# CITY OF ALBUQUERQUE

**Re: Francisco Lopez, Bridge/Eucariz Grading & Drainage Plan (L-11/D067)**  
**Lot 316A, Unit 3, Town of Atrisco Grant Engineer's Stamp dated 09-21-12**

## GRADING & DRAINAGE PLAN

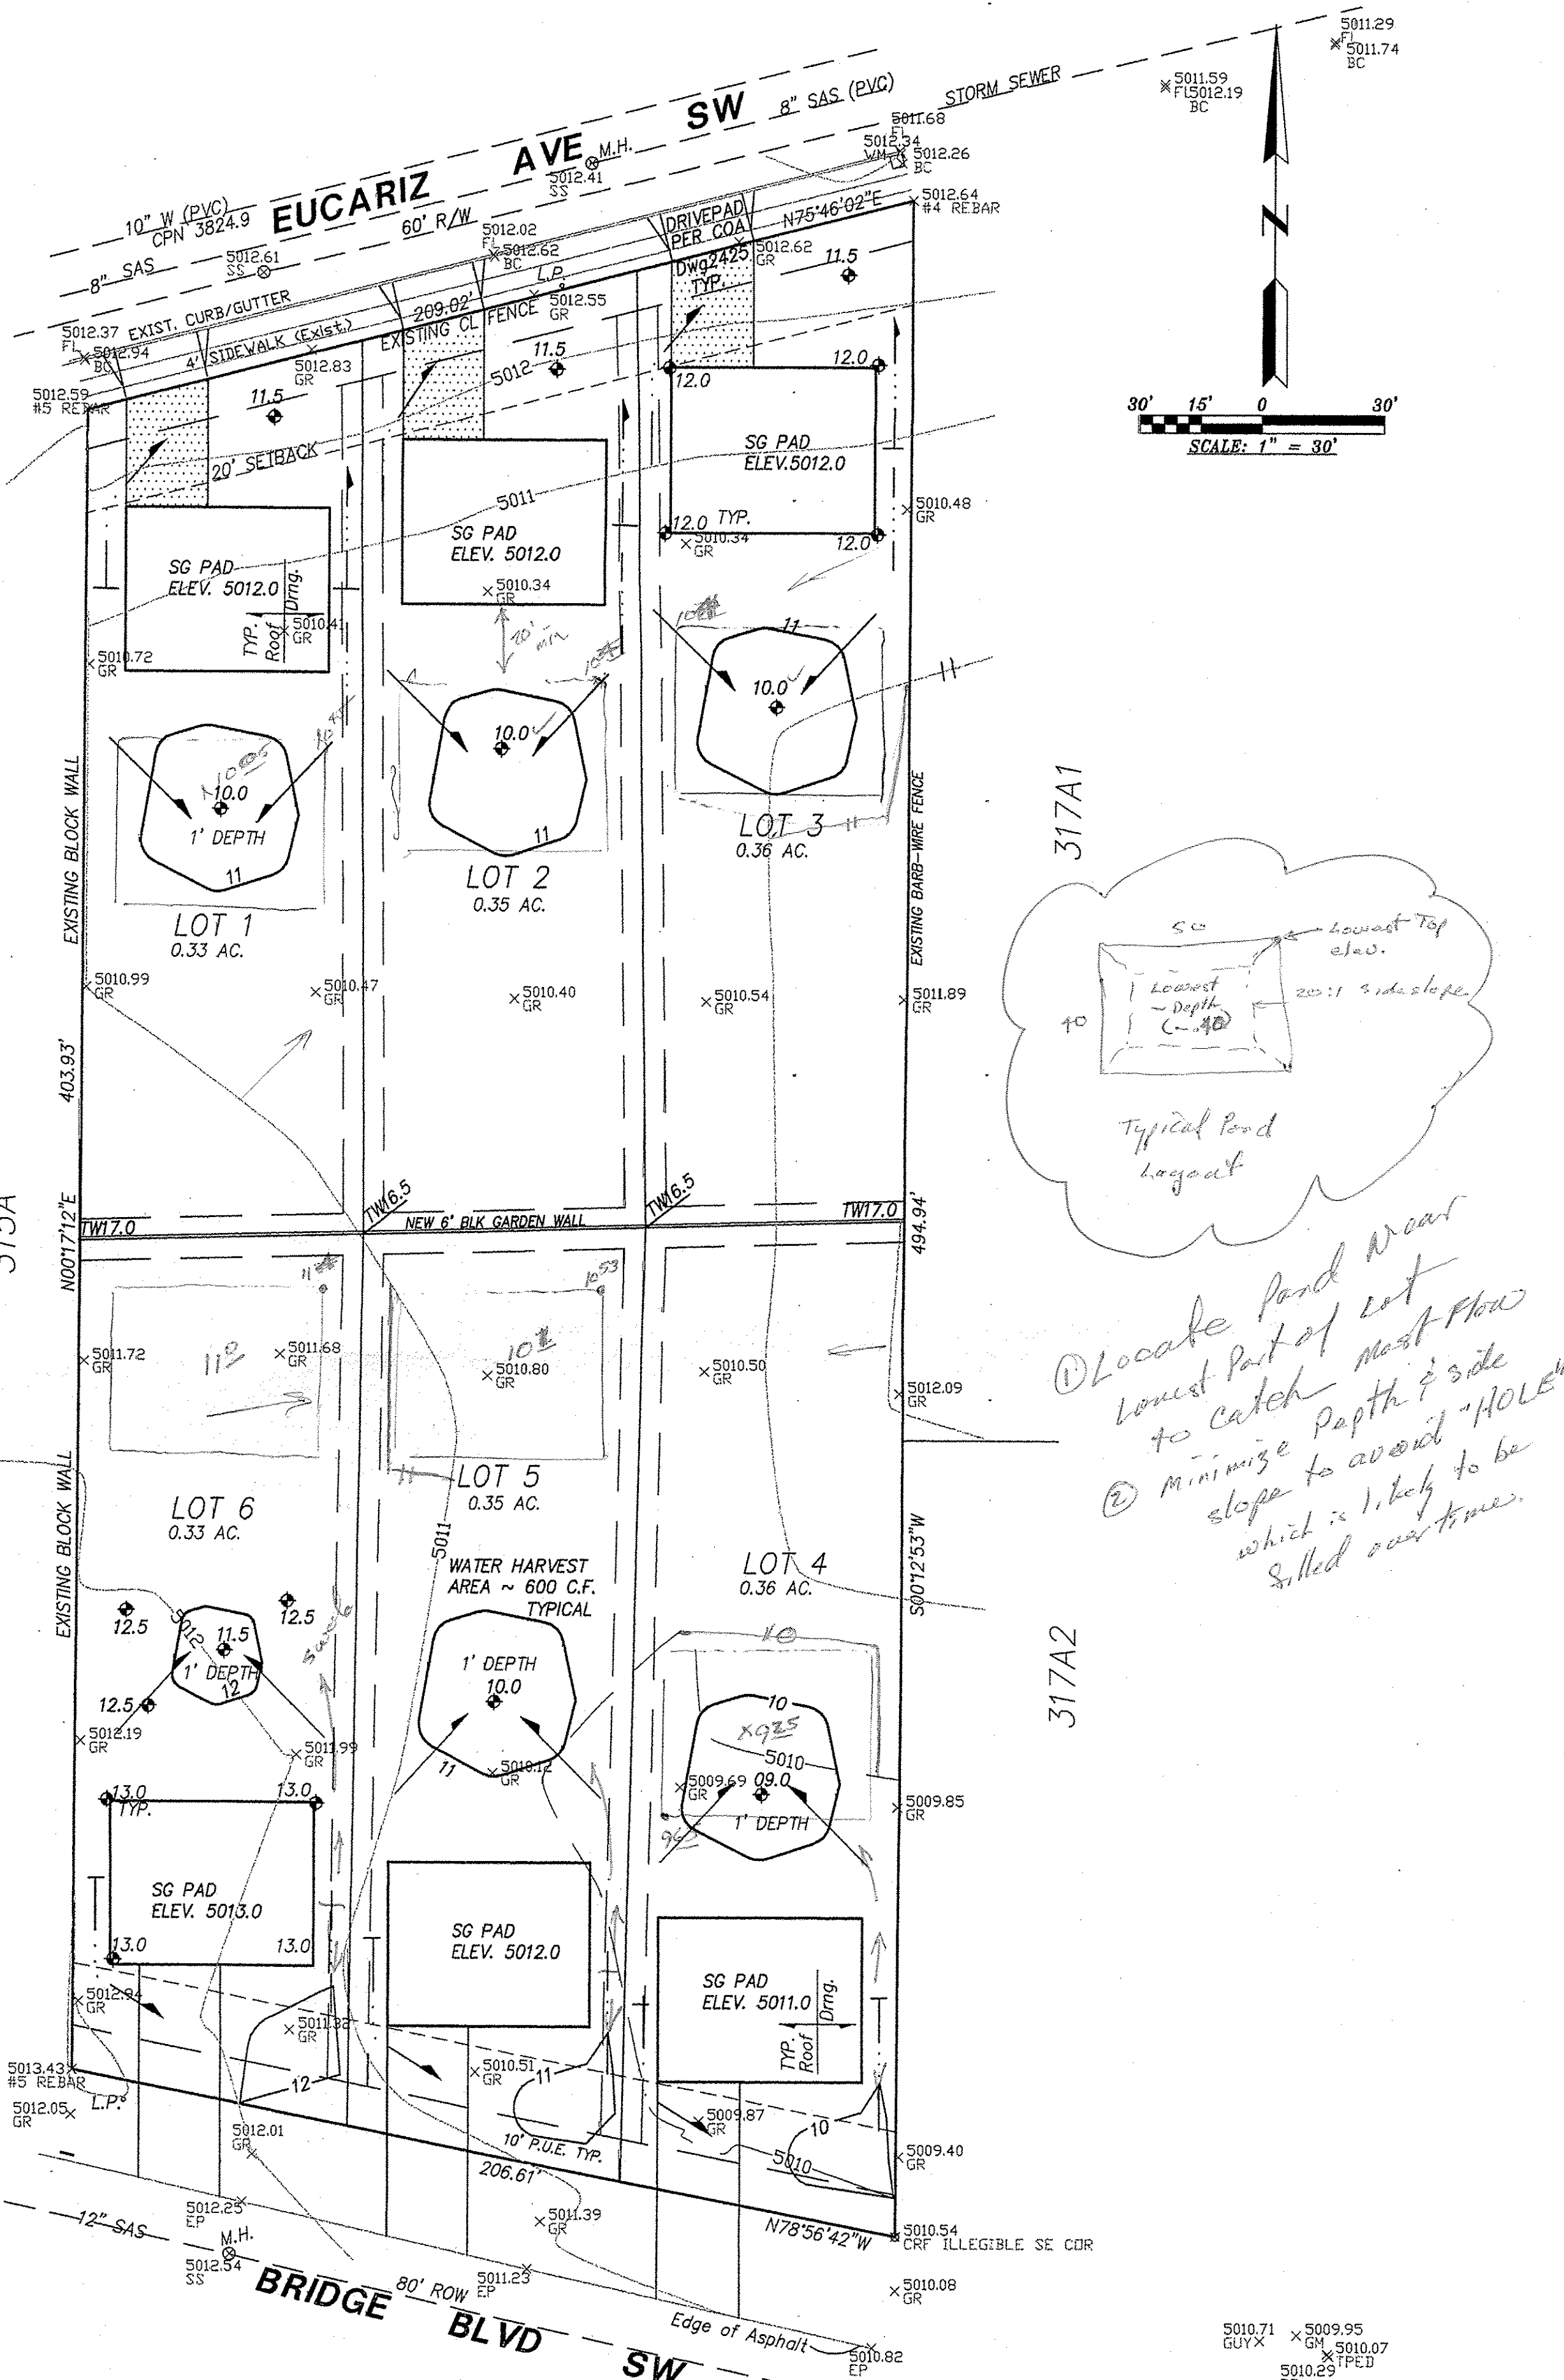
Prior to Final Plat approval or Grading Permit, as you proposed in a subsequent email, the spot elevations on the north lot line for Lots 1 & 2 should be raised to match their respective top of curb elevation to ensure an adequate water block.
